PLANNING APPLICATION CONSULTATION RESPONSE

Application Number:	3/2024/0726
Proposal:	Approval of details reserved by conditions 4 (construction management/method), 5 (site access and off site works of highway mitigation), 11 (car park surface water drainage), 17 (surface water drainage) and 18 (surface water and pollution prevention) on planning permission 3/2020/0911.
Location:	Shackletons Garden Centre Clitheroe Road Chatburn BB7 4JY

Lead Local Flood Authority Position

The Lead Local Flood Authority is able to **recommend the discharge of condition 17** on planning decision 3/2020/0911.

Title:
PROPOSED CONSTRUCTION STAGE DRAINAGE GENERAL ARRANGEMENT

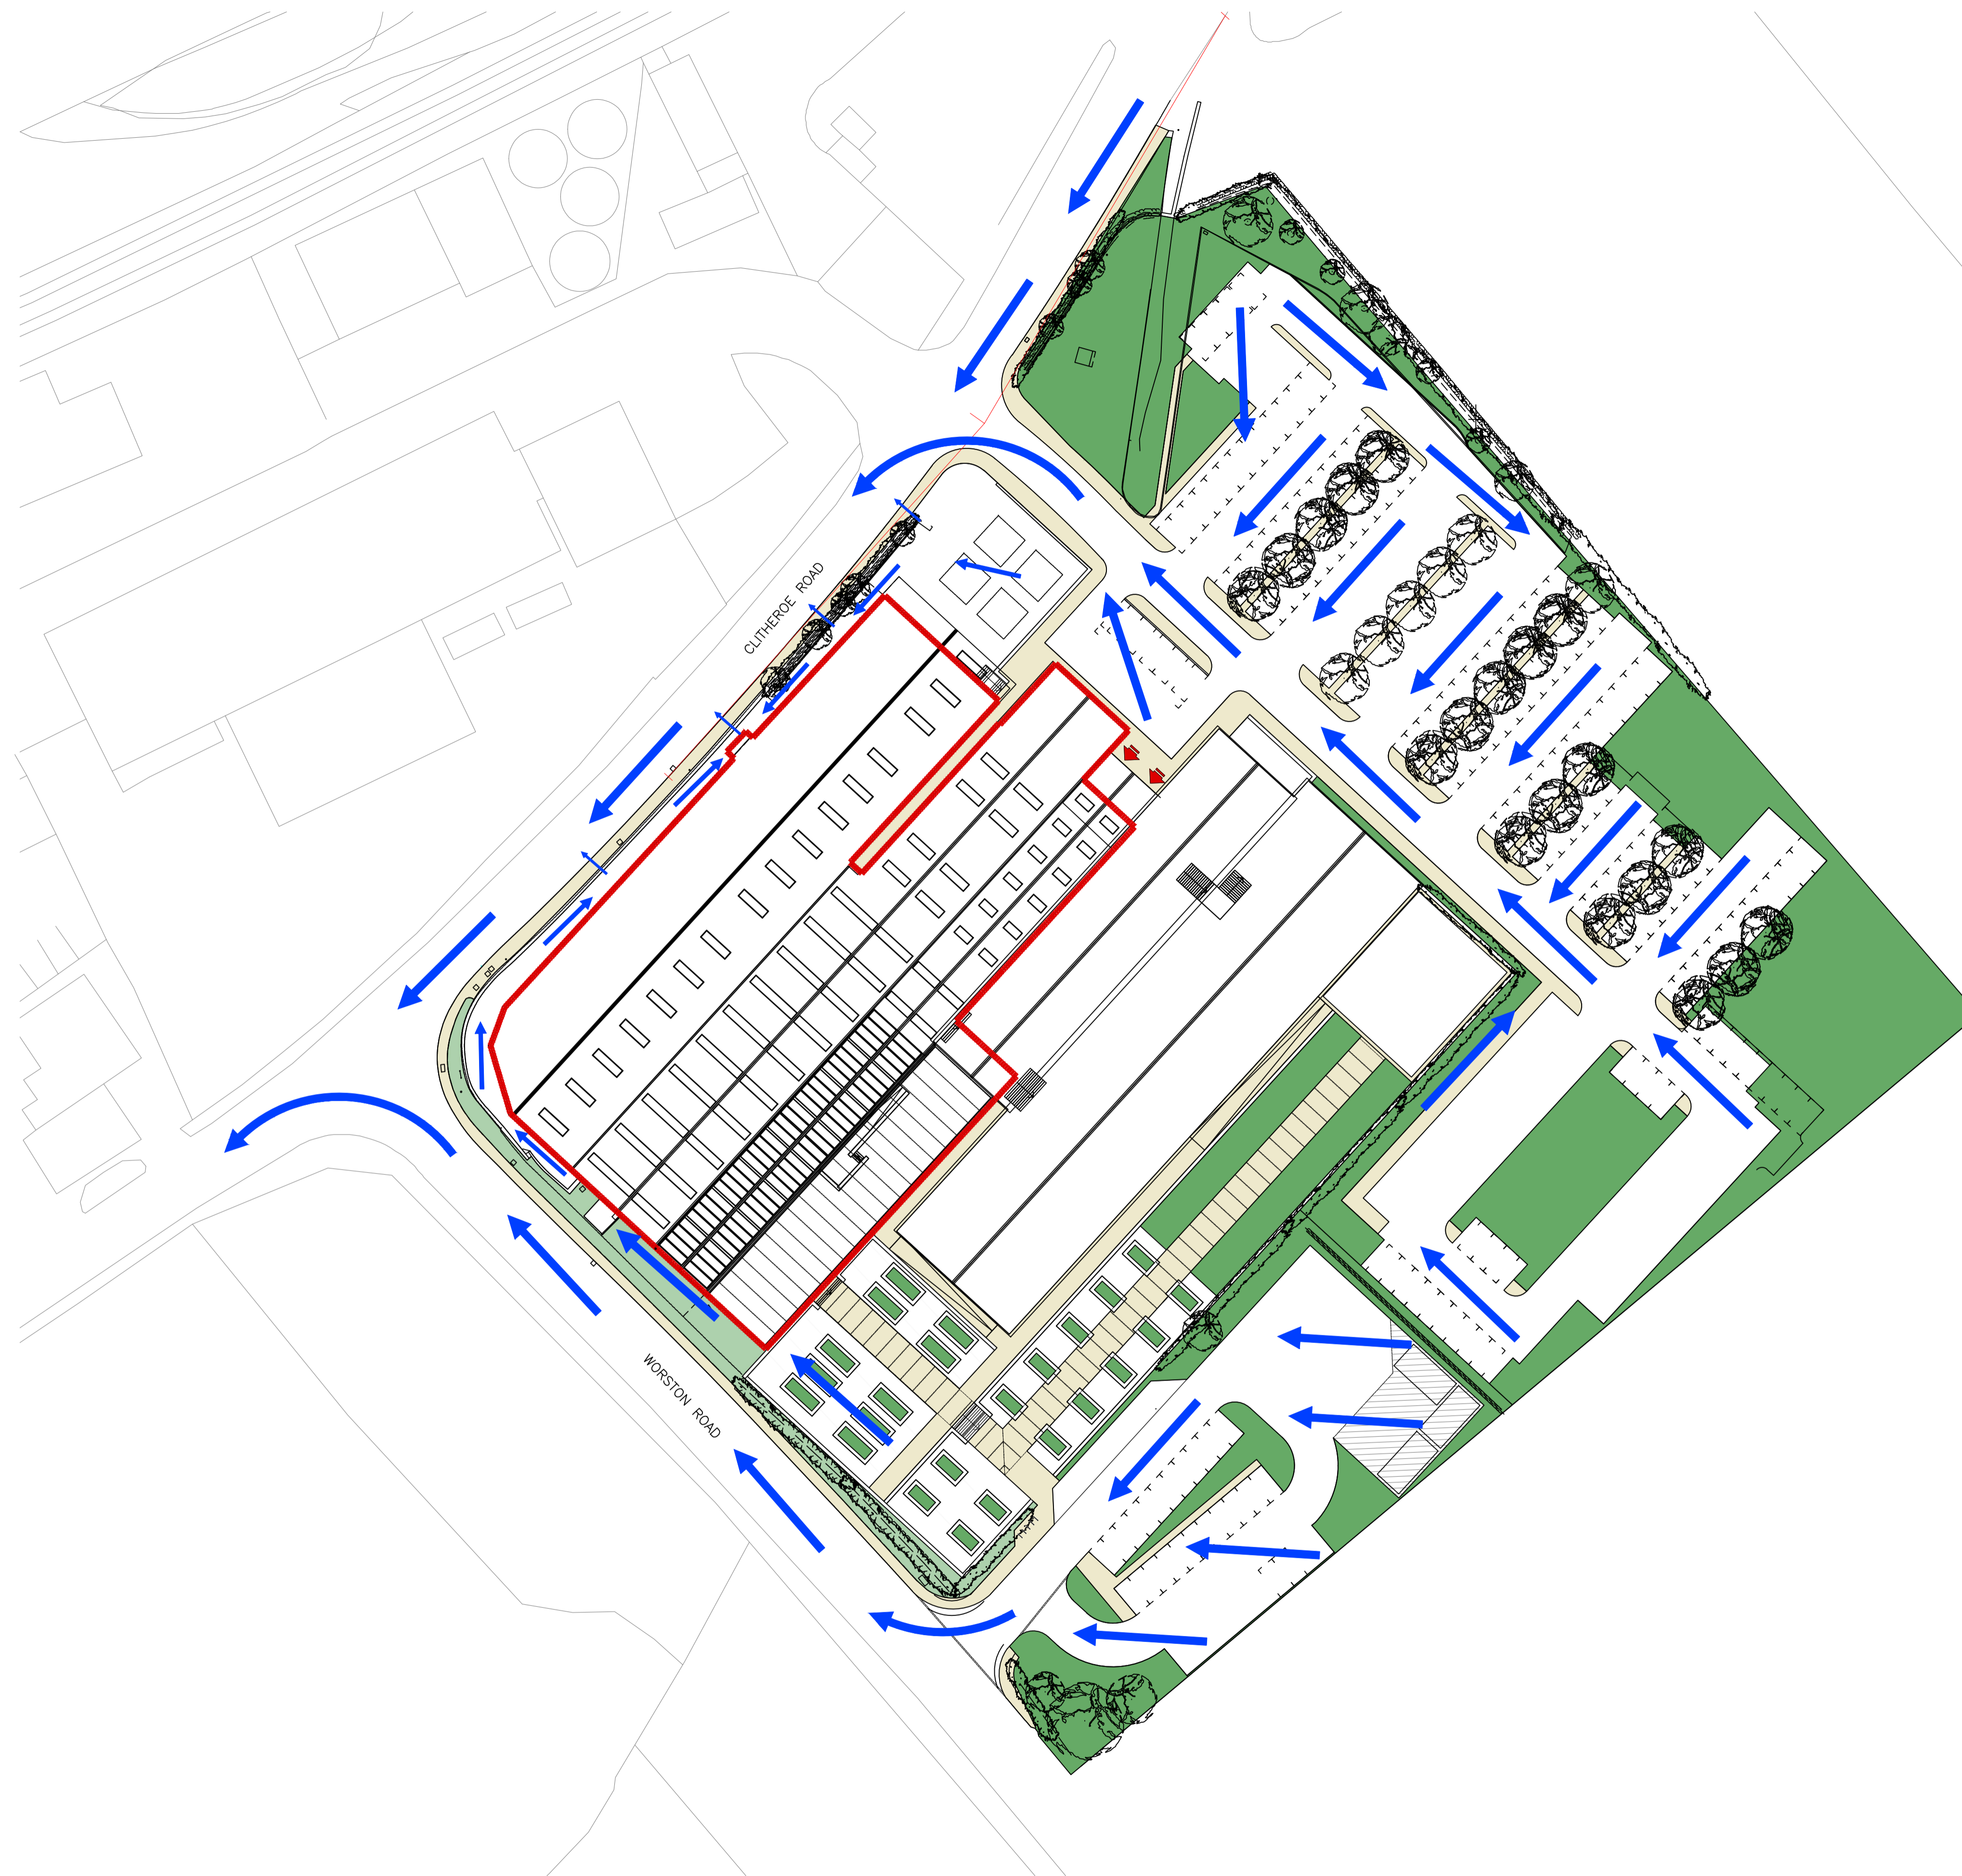
The applicant should ensure that surface water will be discharged from the temporary drainage system during the construction phase and the proposed settlement pond at a restricted rate, similar to that as the proposed discharge rate to the northern discharge location post development.
